PLANNING CONSULTATION RESPONSE

Application No	2025 0908
Proposal	Re-engineering and restoration of Yew Tree Quarry
Address	Stairfoot Brickworks, Wombwell Lane, Stairfoot
Date of Consultation Reply	09/04/2026
Consultee	BMBC PROW - S Ford

Proposed Site Access Arrangements

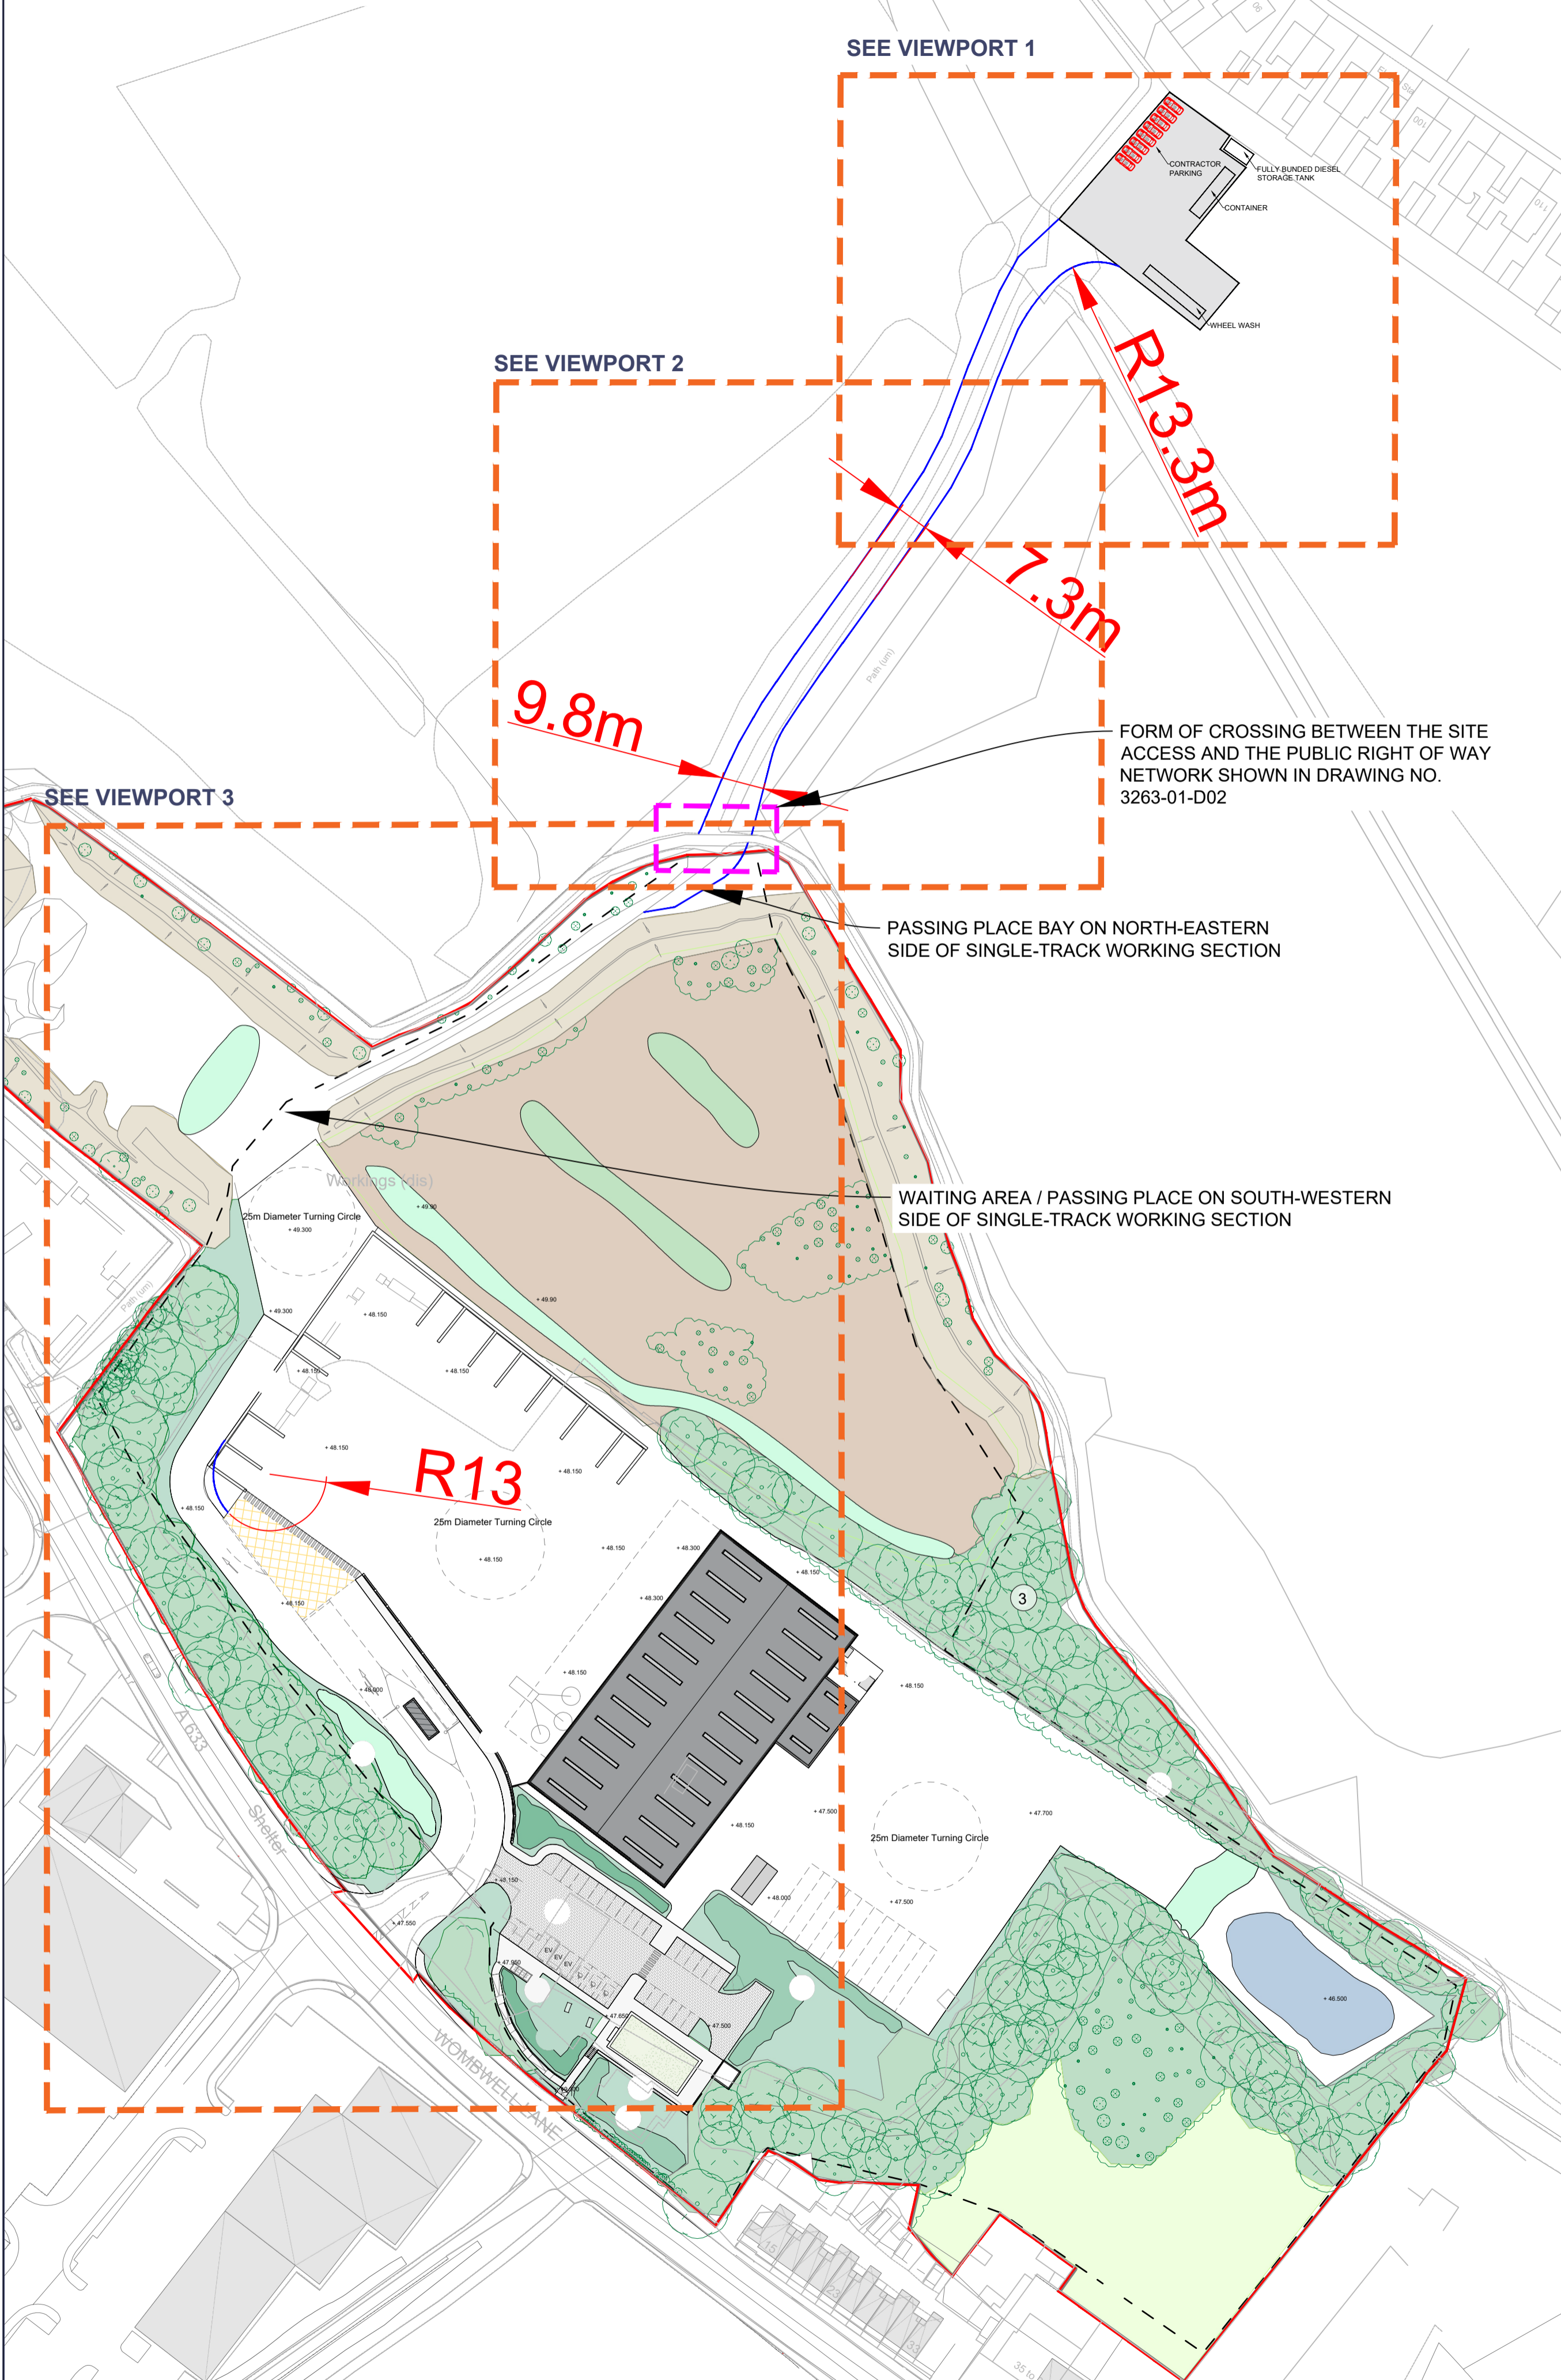
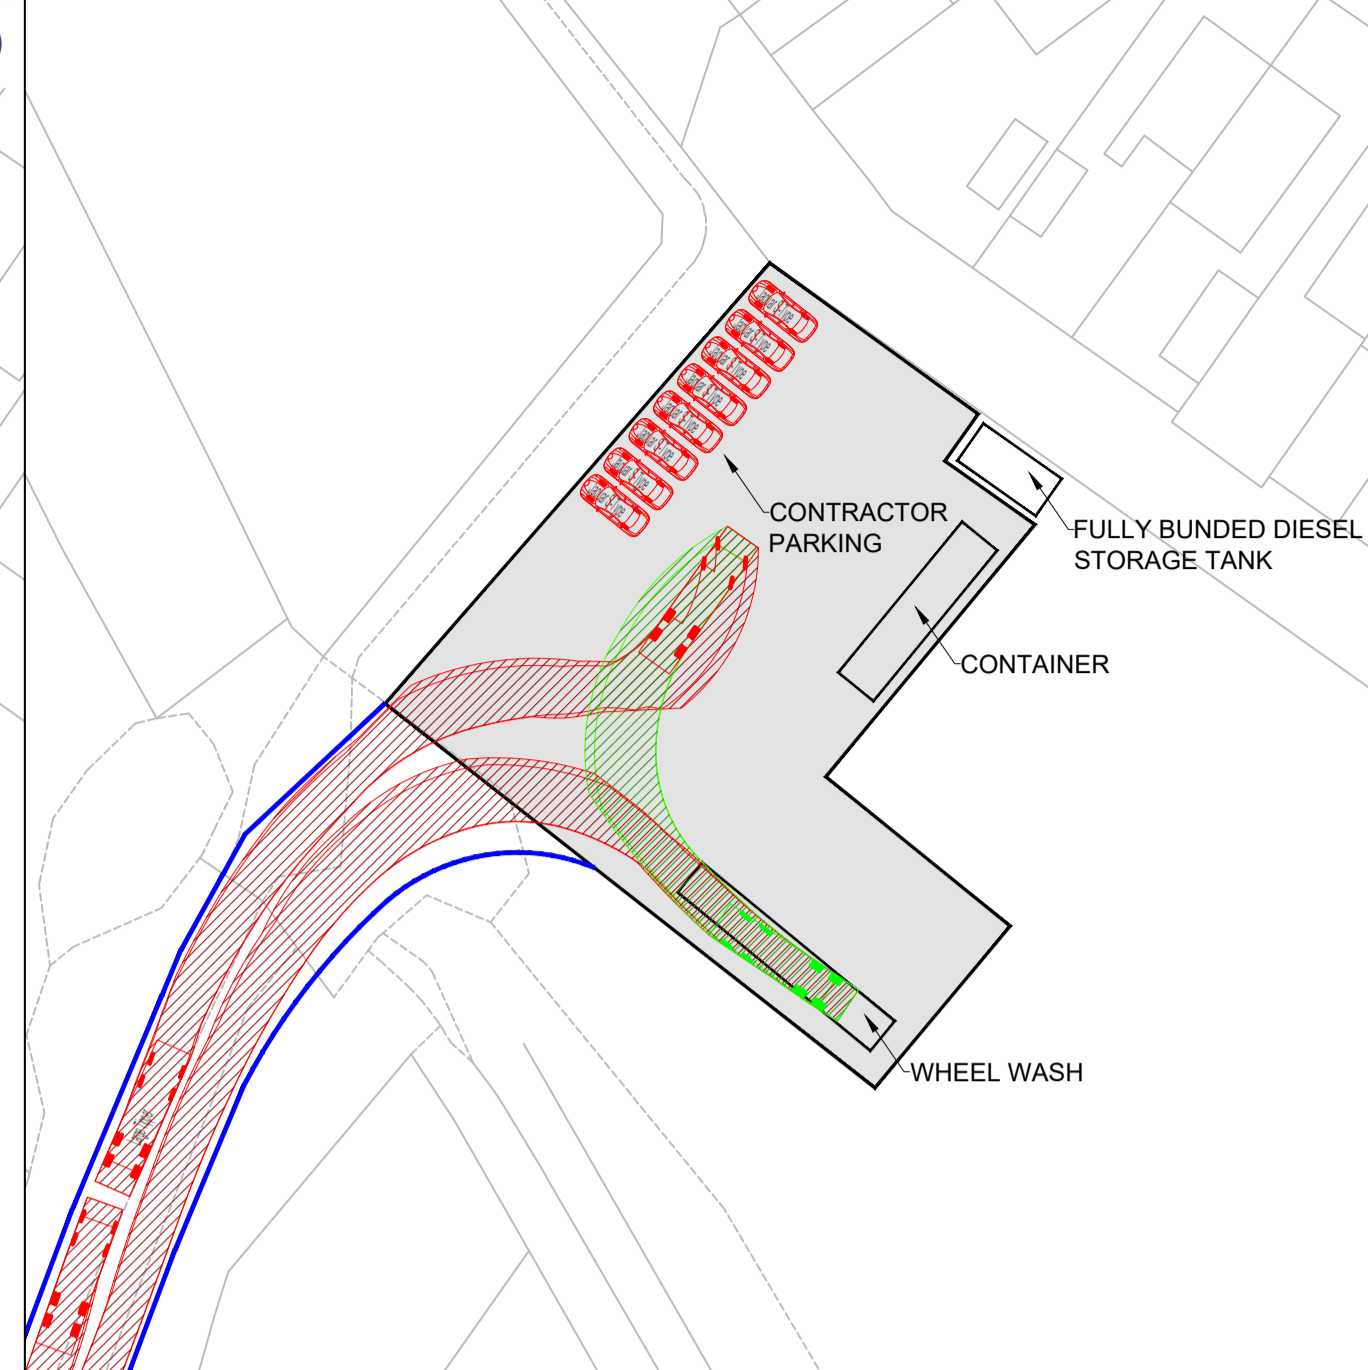
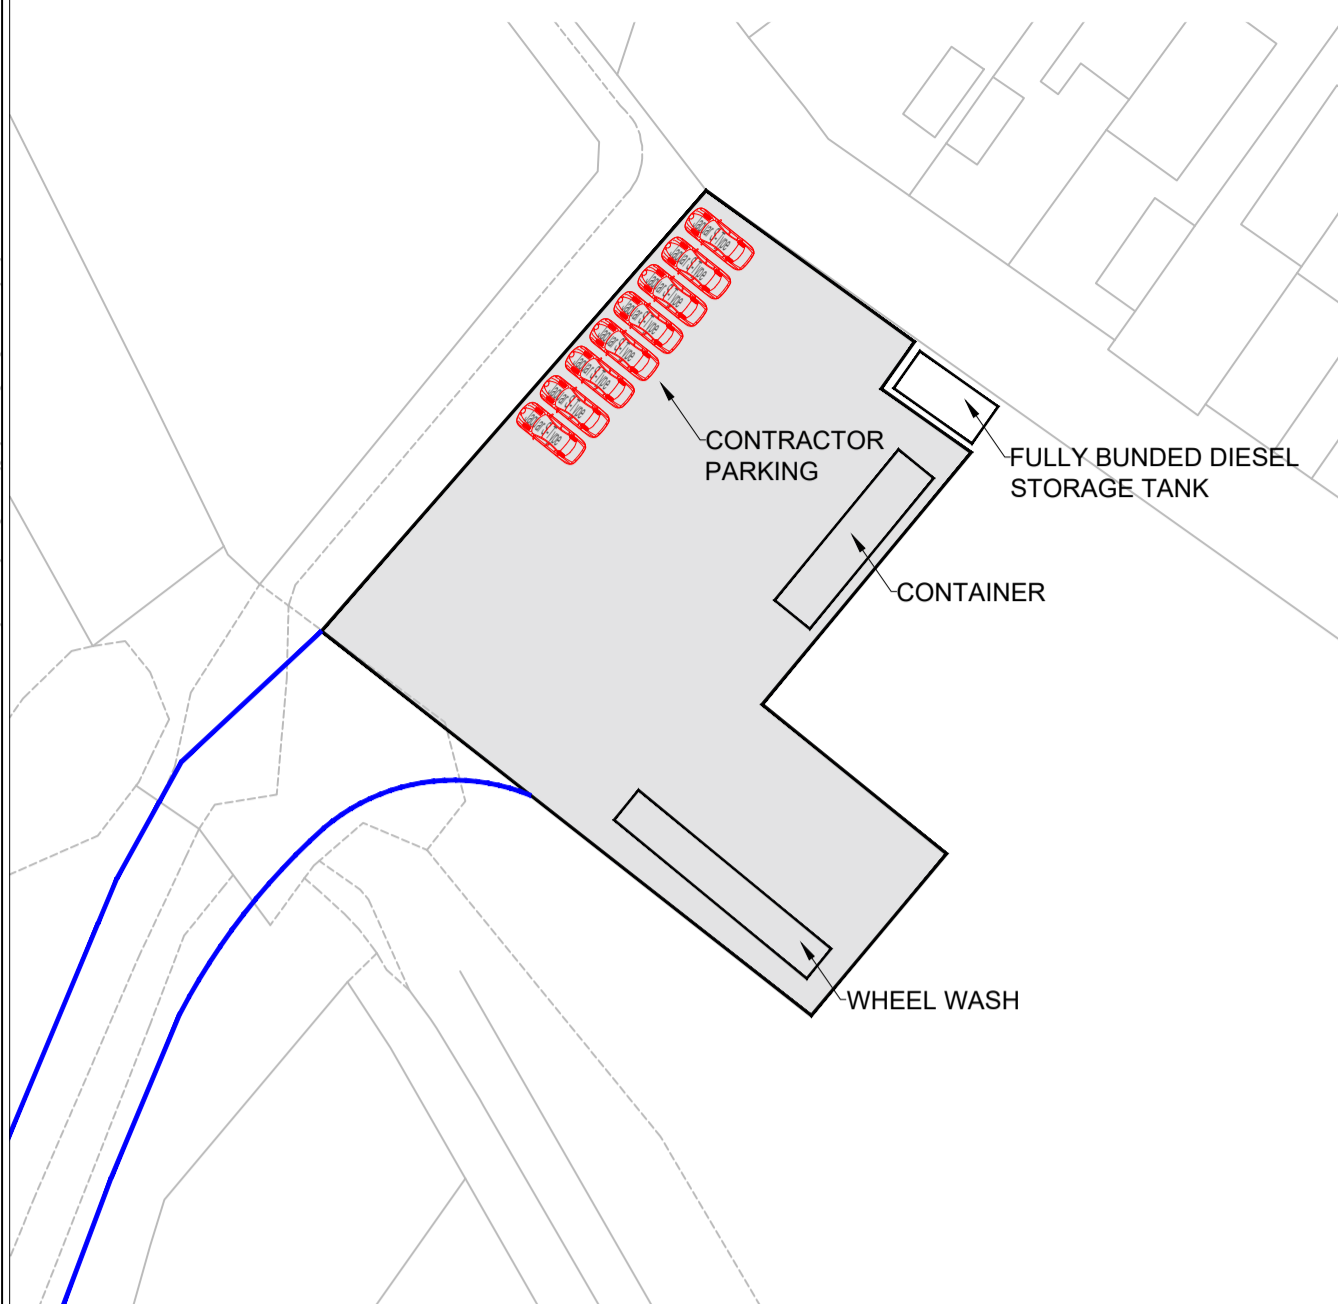
Not sure what this adds in relation to TPT or PROW but the TPT crossing is covered in the Delivery management plans
